Department of Primary Industries

**Barangaroo South Stage 1 Public Domain Works (SSD_6303)
Response to exhibition of Environmental Impact Statement**

Barangaroo South Stage 1 Public Domain Works (SSD_6303) Response to exhibition of EIS Additional comments by NSW Office of Water

Diagram - Tree Plan

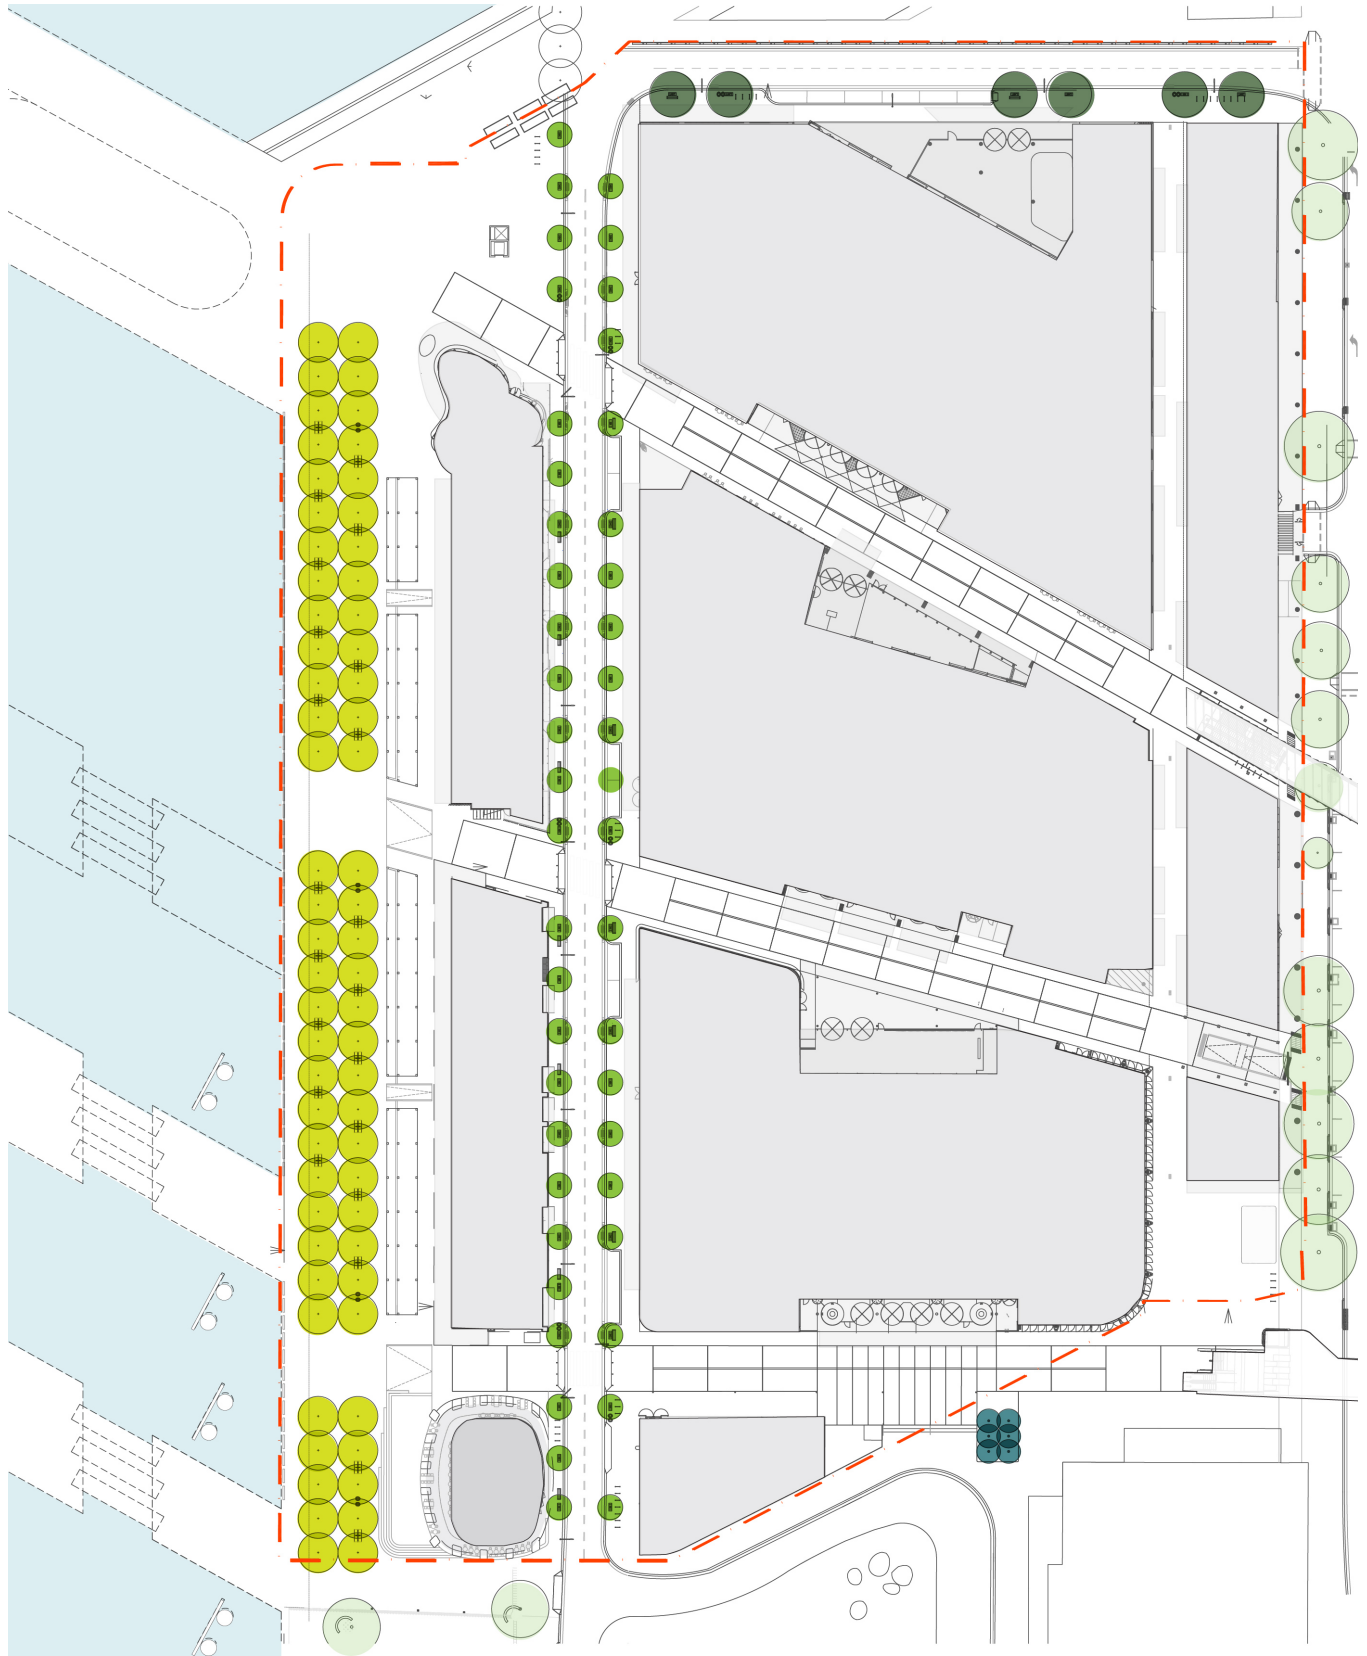
The EIS notes the Waterfront Promenade is proposed to be planted with a double row of Honey locust (*Gleditsia triacanthos*) (see Section 3.4, page 26). The proposed use of *Gleditsia triacanthos* is of concern and it is recommended that unless it can be demonstrated that "Shademaster" is a non-invasive variety, Honey locust, should not be planted along the waterfront.

In terms of protecting riparian habitat around the harbour and its waterways, the Office of Water recommends the EIS (dated May 2014); the Stage 1A Landscape Report (dated 7 April 2014, in Appendix A of Volume 1 of 2); and the Tree Planting Strategy (Drawing No. LA_MP_AO_DA210, dated 5/5/2014 in Volume 2 of 2) are amended to:

- delete any reference to planting Honey locust at the Barangaroo development site from these documents,
- use local native plant species from the relevant vegetation community along the waterfront.
